Consultation Response from KC, Trees
2024/93605 Land at, Main Avenue, Cowlersley, Huddersfield, HD4 5US
Erection of 57 dwellings with access from new through road connecting Main Avenue and Windsor Road, and associated works, including engineering and landscaping
Date Responded: 17/02/2025 Responding Officer: JD Responding Ref:

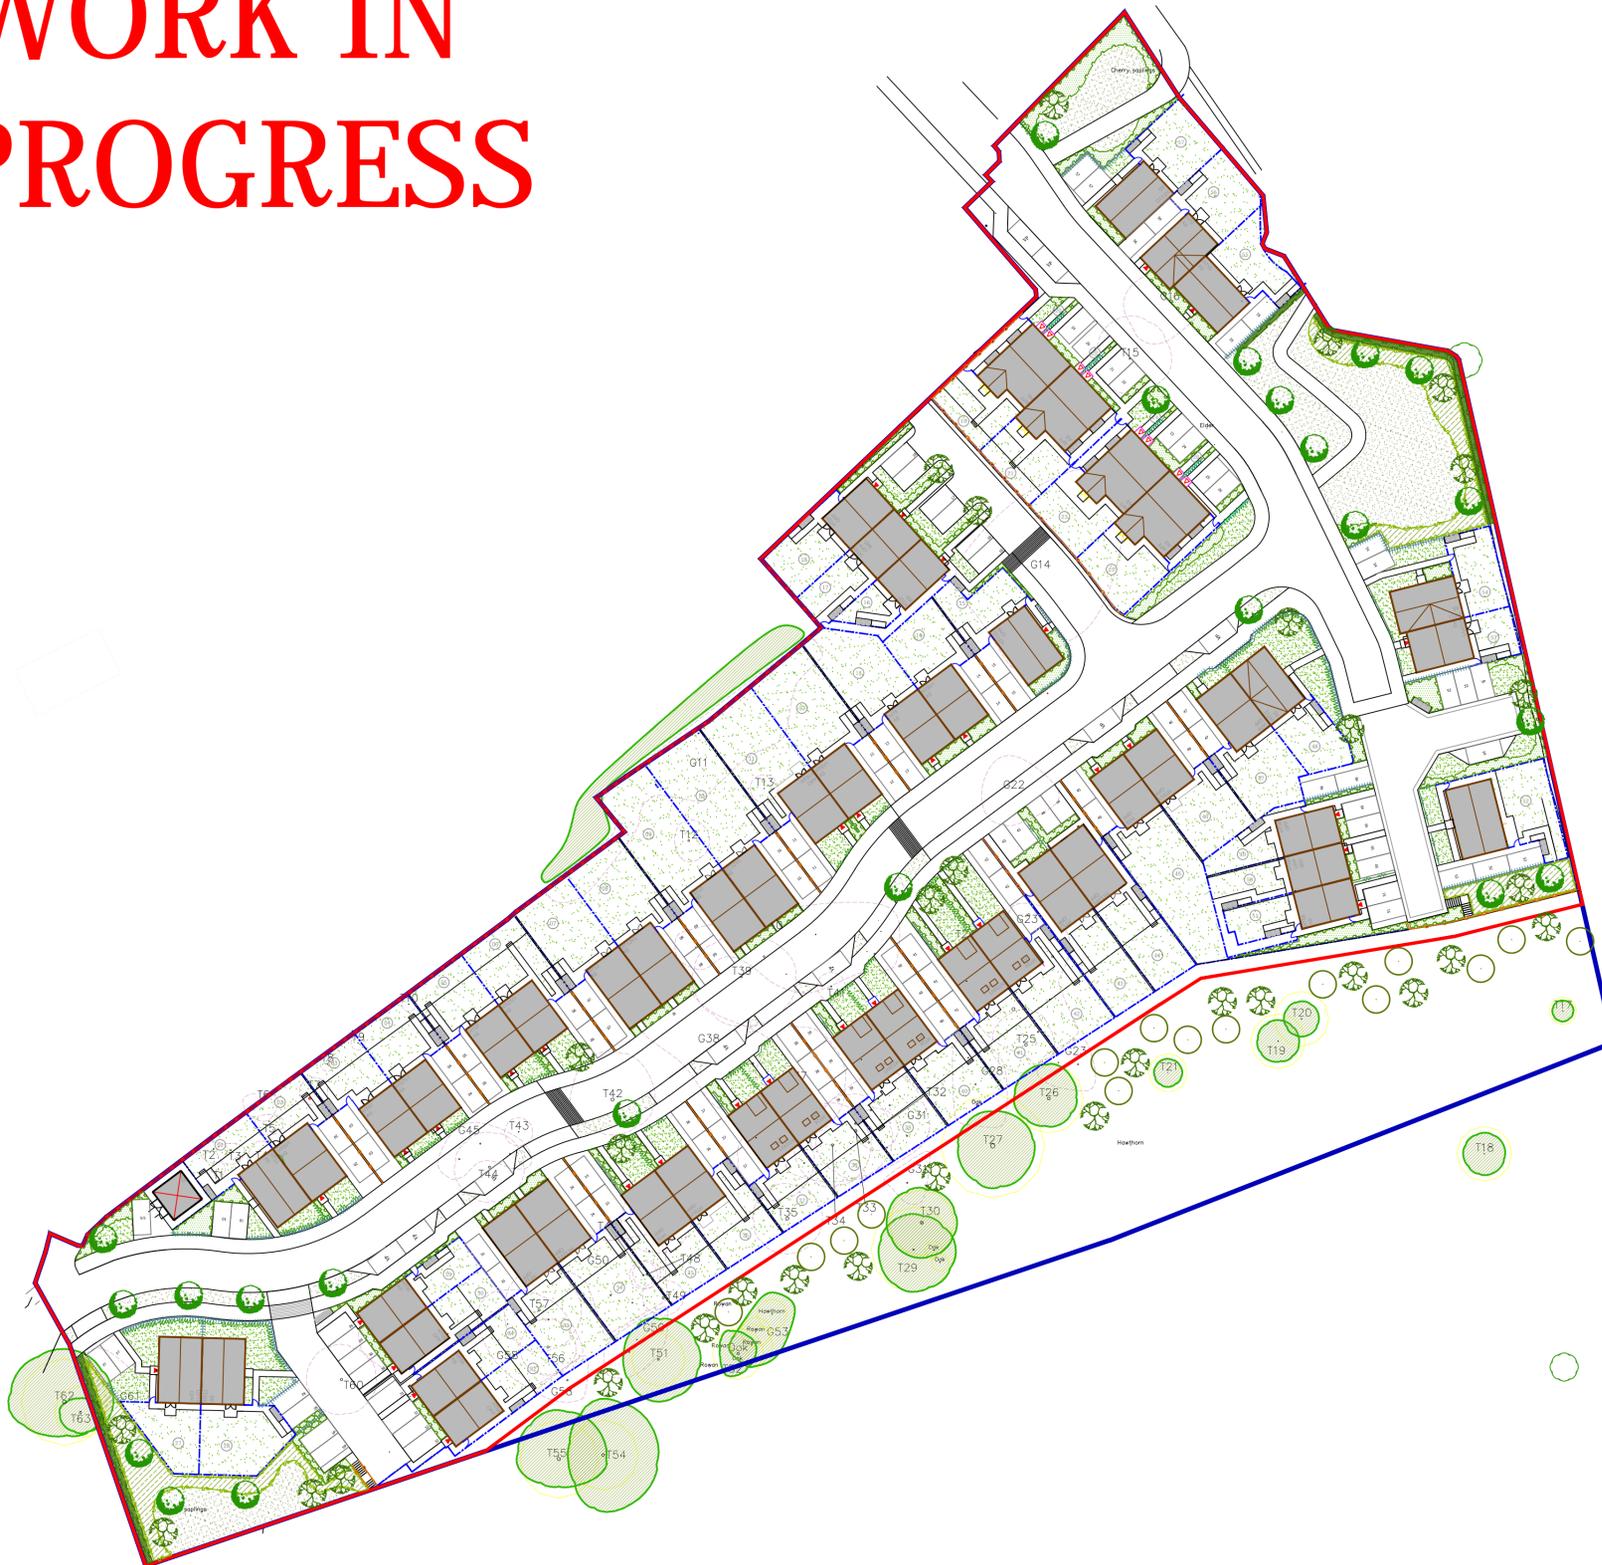
After reviewing the revised landscape master plan (Rev F), there has been a substantial increase in mitigation planting and the species proposed for planting are closer aligned to those that currently exist within the site.

I am now confident that these proposals sufficiently mitigate the loss of existing site trees and there is no longer an objection to the development from a trees perspective.
